Re: Planning Application 20/0318

Address: 23 Bridge End Billington BB7 9NU

Description: Demolition of existing two-storey storage building and erection of one new, detached dwelling to match existing, to be used as holiday accommodation.

proposed site plan. scale: 1:500

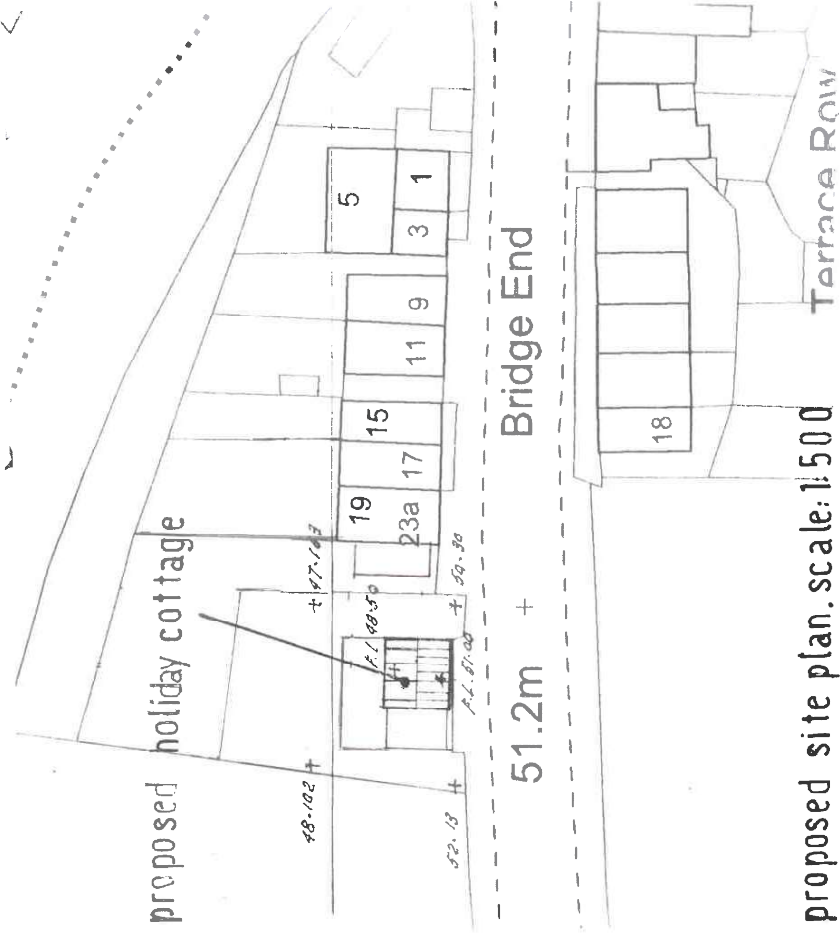
It is noted that there appears to be a wall beneath the existing building that may provide some third party support to the highway. It is expected that any further works adjacent to the highway will need to be accessed to ensure that the structural integrity of the highway is maintained.

In order to fully support the development we would look to approve the plan(s) regarding the construction of the retaining wall. It is noted that there is a wall that will act as a retaining wall for the existing highway, in order to provide assurance that it has design using sound practices we would expect some supporting documents as detailed in the Design Manual for Roads and Bridges paying due regard to Annex A1a , C1 and C6.

There will need to be some works carried out to the highway to lower and raise the kerb line as required and to re-site a street lighting column which will hinder the access to the drive. It is expected that these will need to be carried out as part of a Section 278 agreement.

3. No part of the development hereby approved shall commence until a scheme for the retaining structure adjacent to the highway has been submitted to, and approved by, the Local Planning Authority in consultation with the Highway Authority. **Reasons:** In order to satisfy the Local Planning Authority and Highway Authority that the final details of the retaining structure are acceptable before work commences on site.
